Item No. **Report of the Head of Planning, Building Control, Sport & Green Spaces**

Address THE OLD MISSION HALL 44 WATERLOO ROAD UXBRIDGE

Development: Demolition of existing buildings and erection of 2 x semi detached dwellings
(Application for Outline Permission with all matters reserved)

LBH Ref Nos: 1654/APP/2015/753

Block plan of proposed redevelopment of

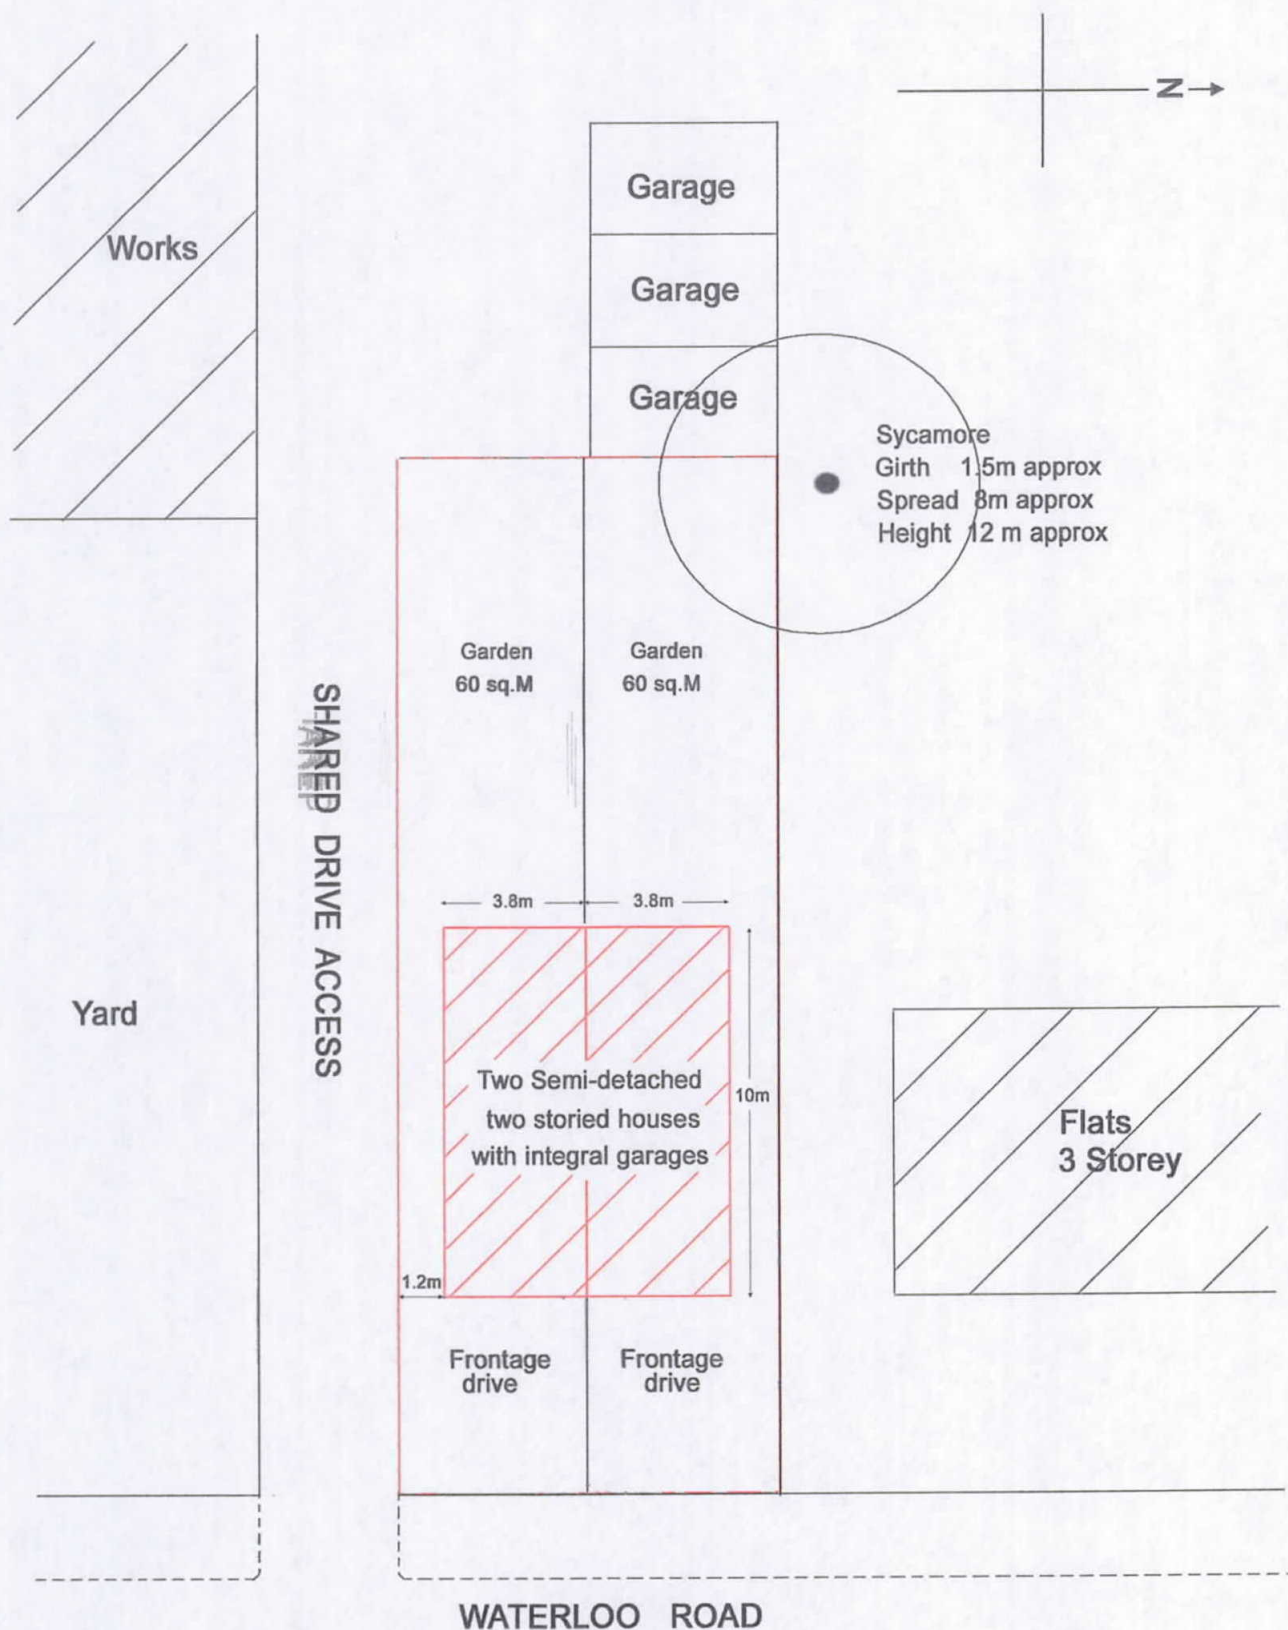
- No tree survey has been submitted.
- According to drawing 2 the off-site sycamore will not be directly affected by the built development and will continue to oversail the existing garages (to the west of the site) and the ends of the gardens. Tree protection should be provided during the demolition and construction period.
- Otherwise, the proposed semi-detached houses appear to be well to the east of the

likely root protection area of the tree.
